KITITAS COUNTY

DEPARTMENT OF PUBLIC WORKS

MEMORANDUM

TO: All Staff
FROM: Public Works Plan Review Team
DATE: November, 6, 2025
SUBJECT: SPF-25-00007 Sageview

SHEET 1 OF 4

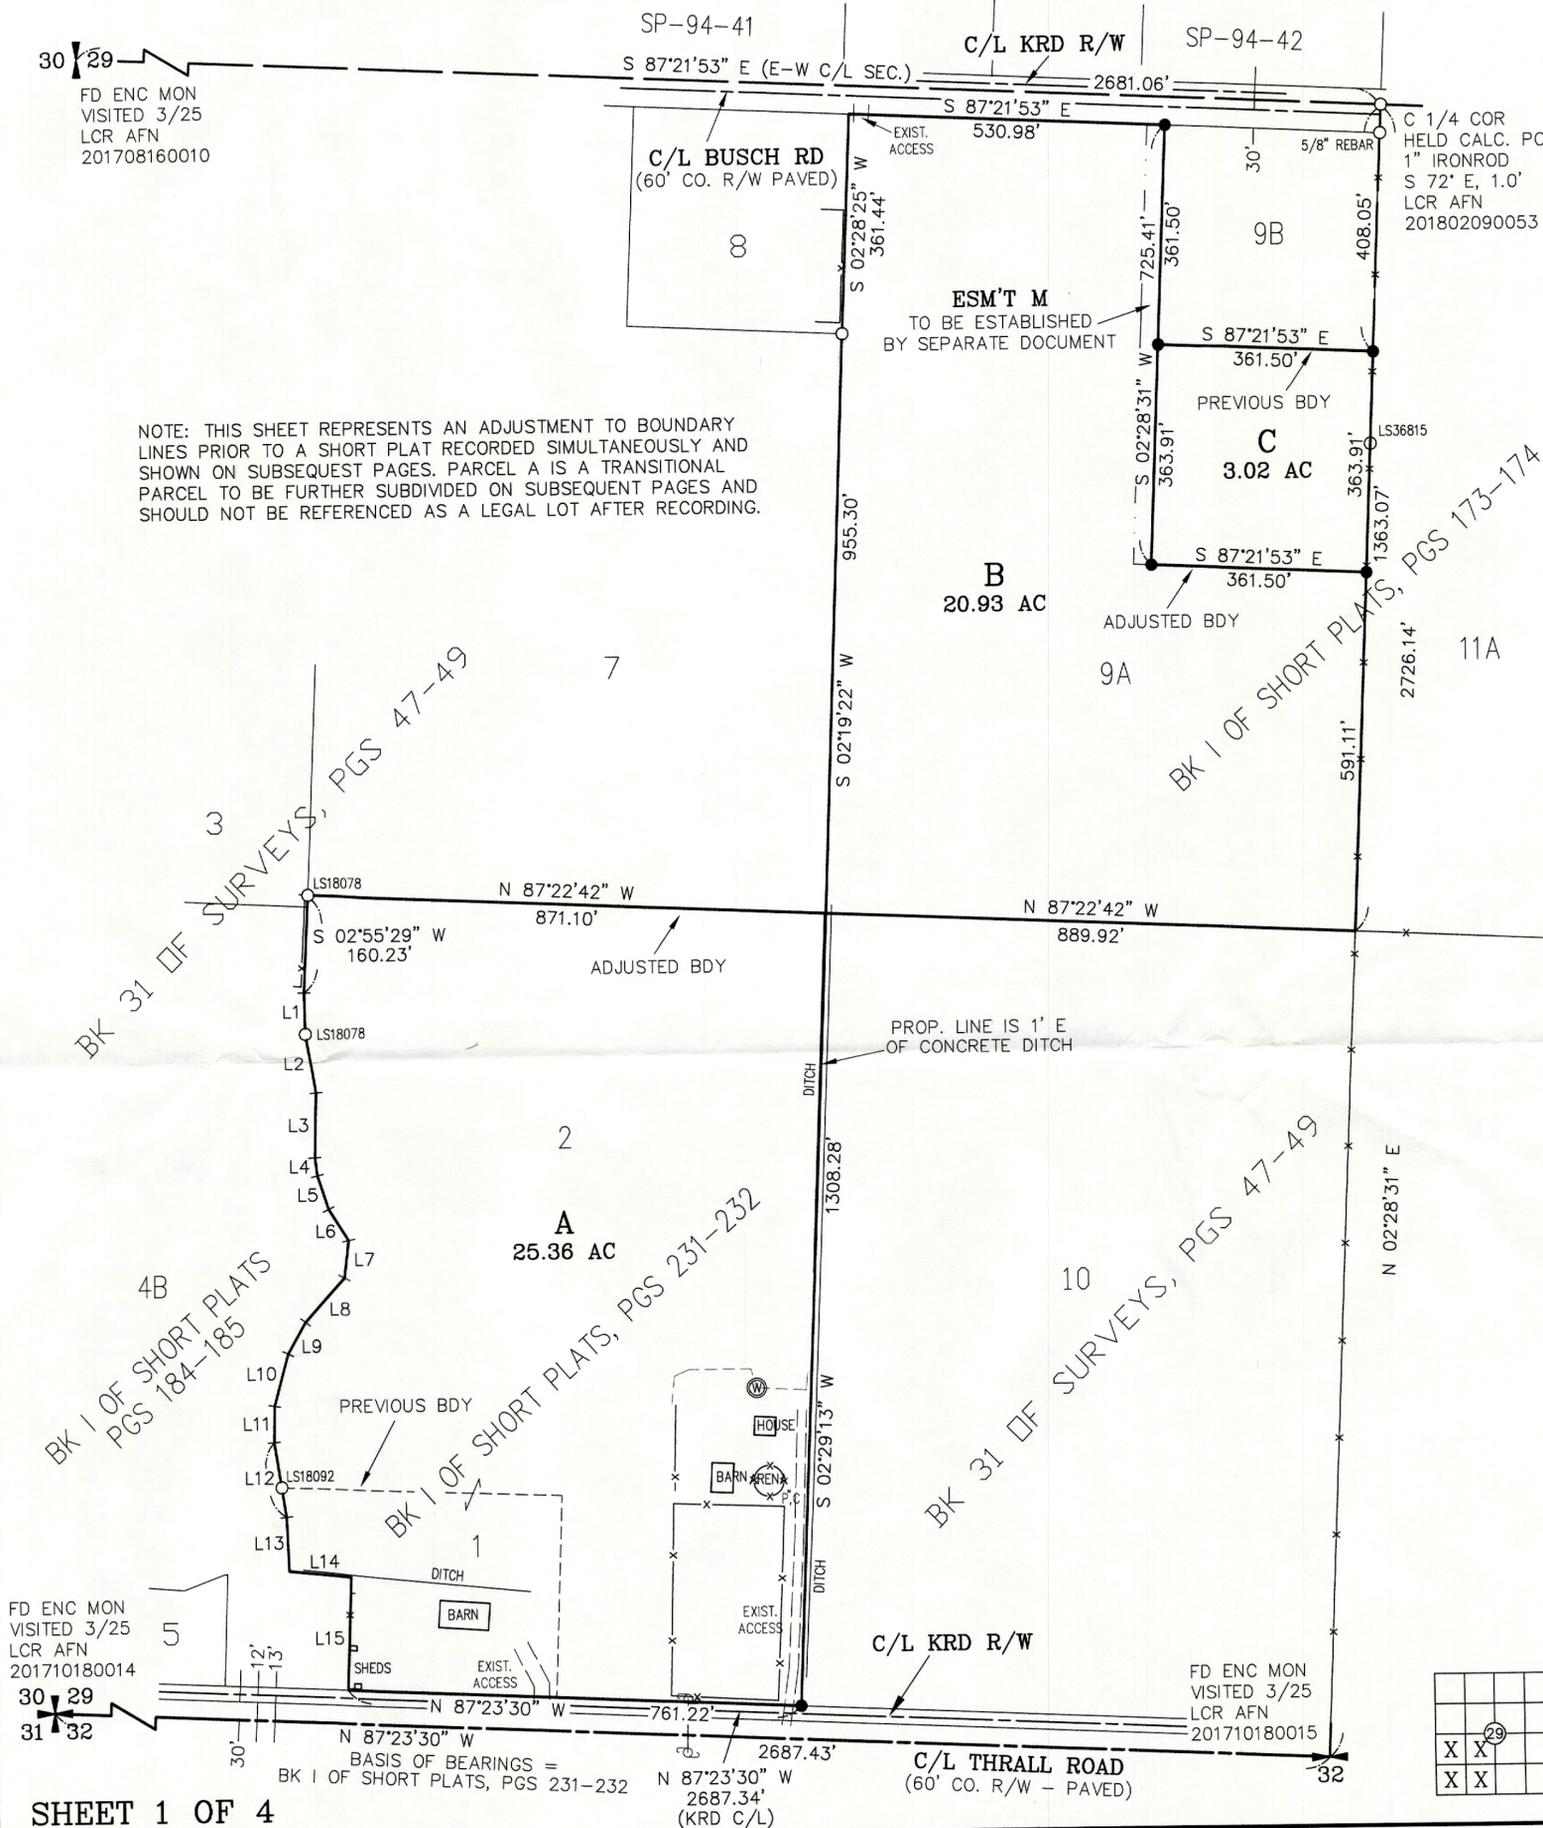
ACCESS	<ol style="list-style-type: none"> 1. An approved access permit shall be required from the Kittitas County Department of Public Works prior to creating any new driveway access or altering an existing access. 2. Maintenance of driveway approaches shall be the responsibility of the owner whose property they serve. The County will not maintain accesses. 3. Any further subdivision or lots to be served by proposed access may result in further access requirements. See Kittitas County Road Standards. 4. In addition to the above-mentioned conditions, all applicable Kittitas County Road Standards apply to this proposal. Access is not guaranteed to any existing or created parcel on this application. 5. Please show "Easement M" with a minimum of 30' width for purpose of access to Lot C. <p>Of Note: Please ensure that Lot A retains the address of 11461 Thrall Rd upon final recording of short plat. (RC)</p>
